STATE OF NORTH CAROLINA  
DEPARTMENT OF TRANSPORTATION

**Addendum No. 1**

RE: Contract # C204851

**Cleveland County (R-2707D, R-2707E)**

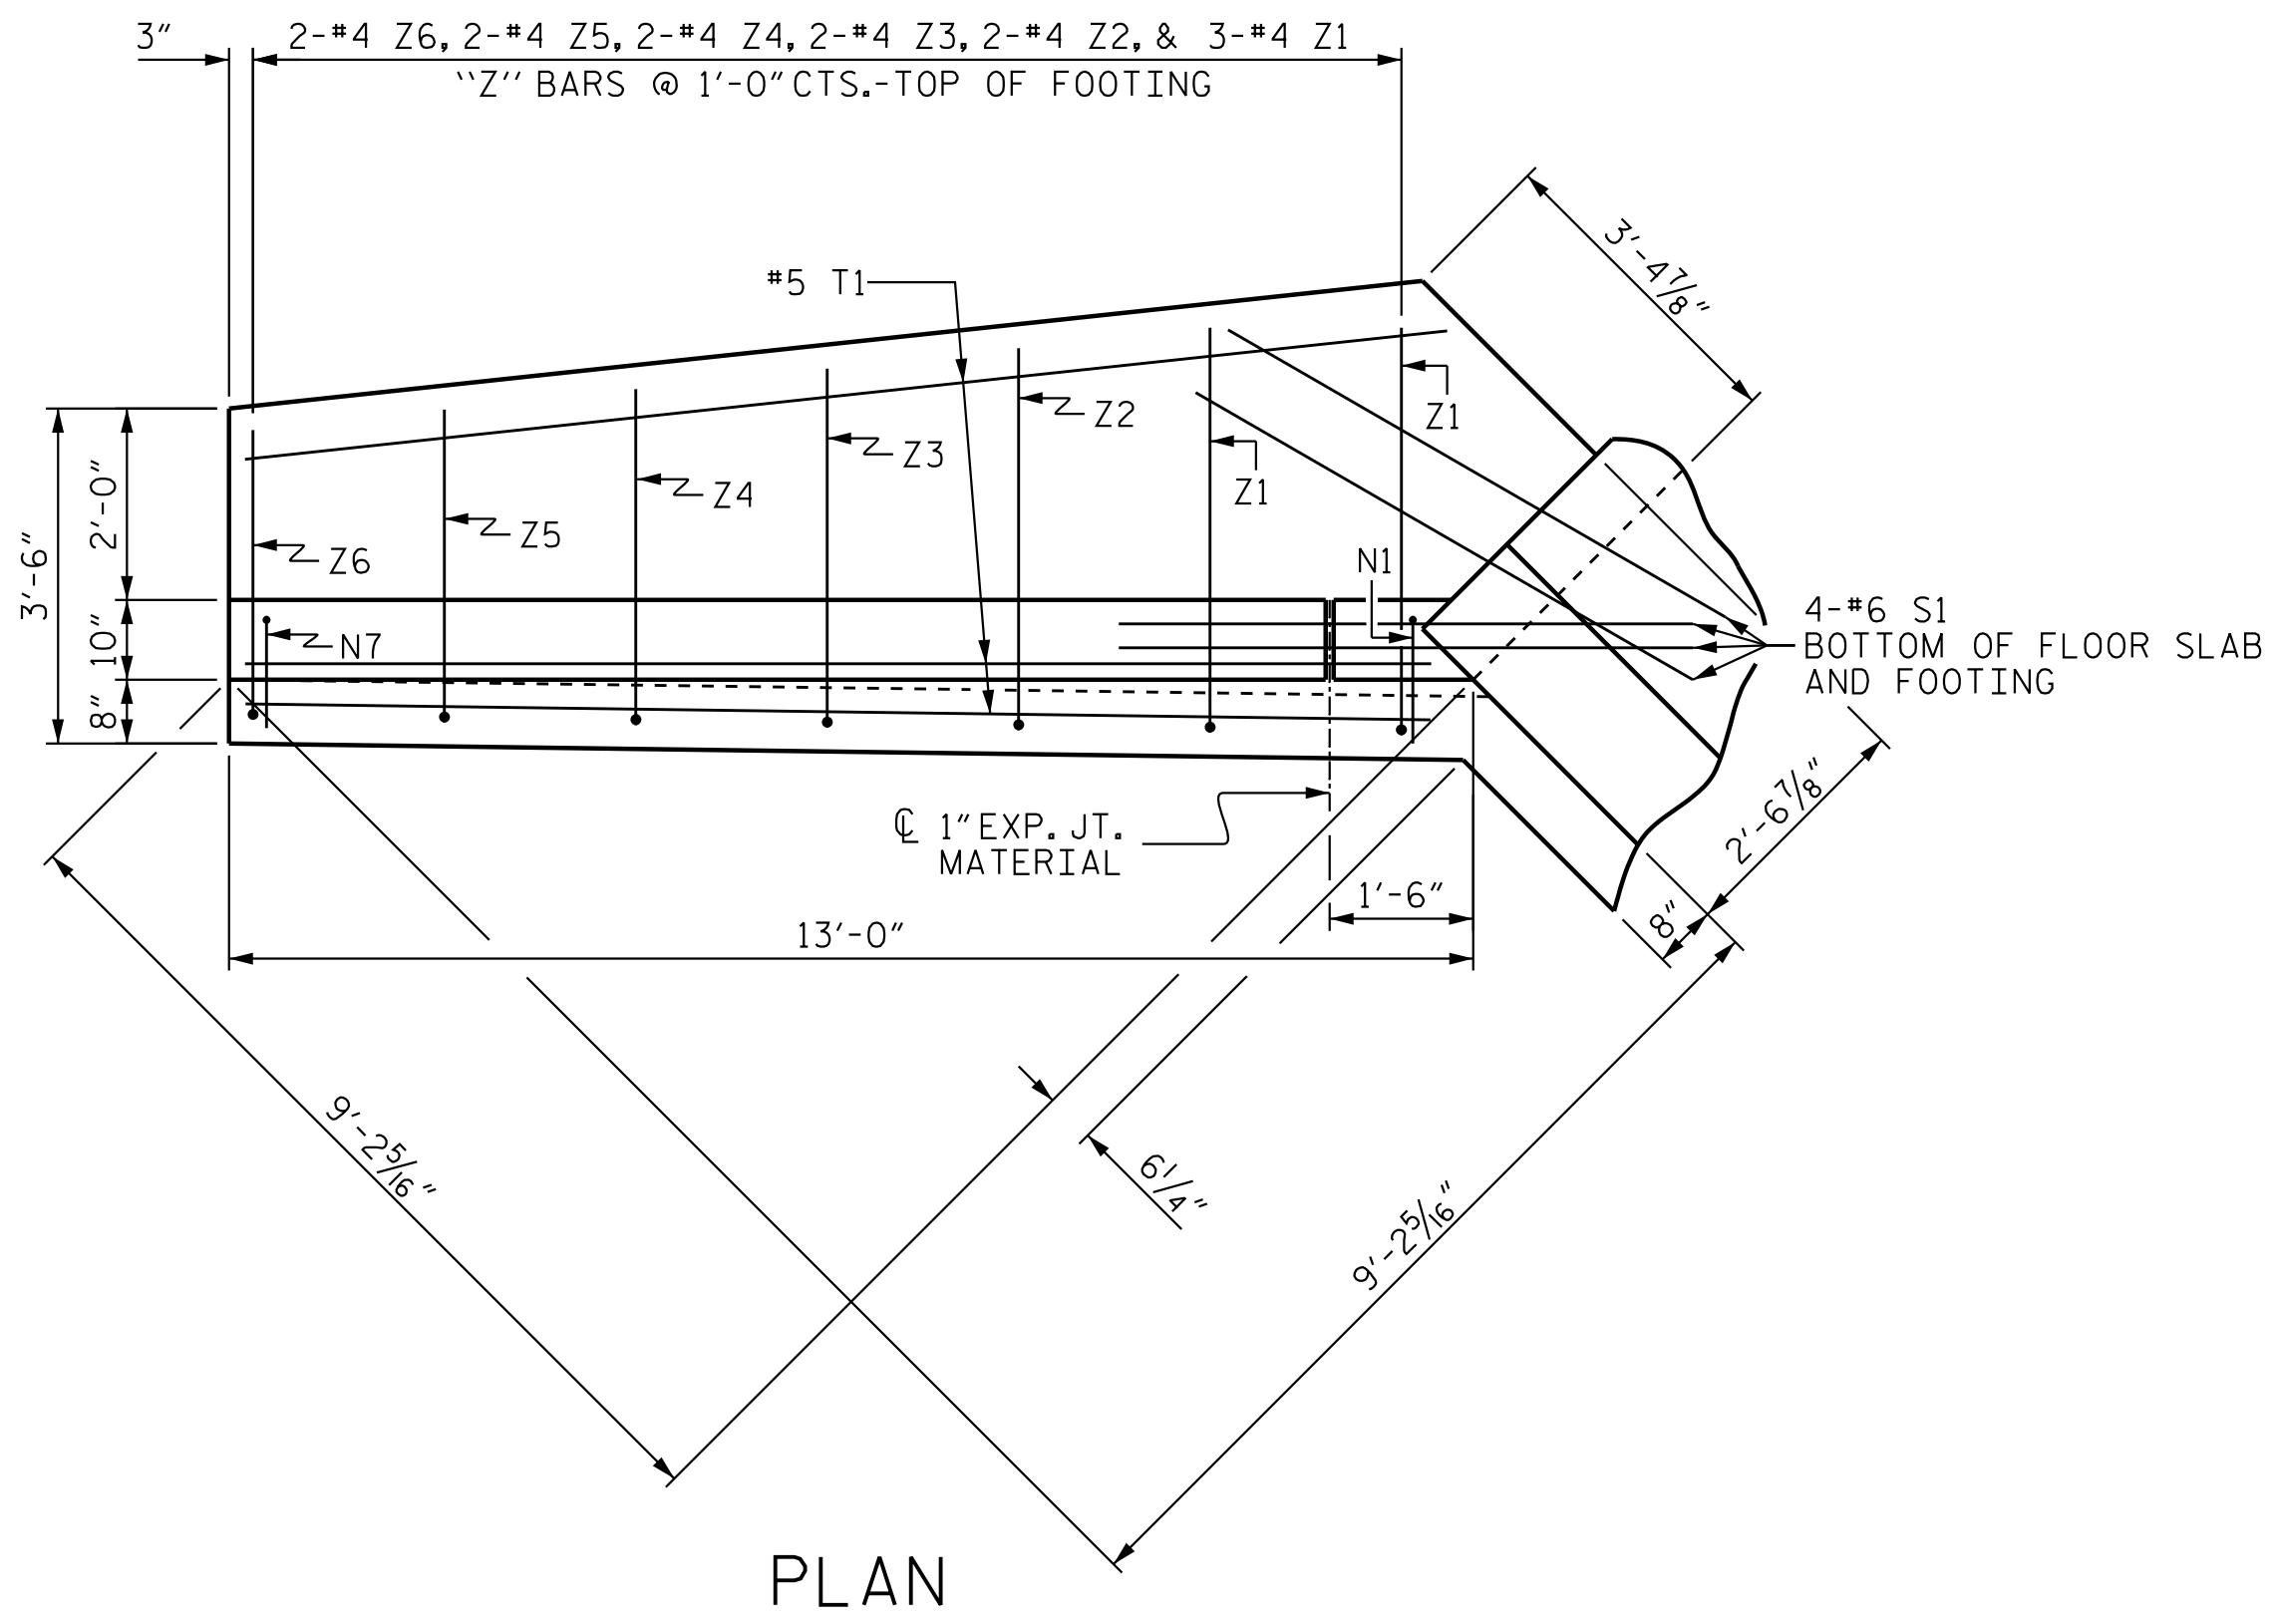
Sheet No.	Revision
S1-19	Changed total weight of reinforcing steel for barrier rail to 9,166 lbs.
S1-21, S2-23, S7-22, S8-19, S9-19	Changed superstructure Class AA concrete volumes.
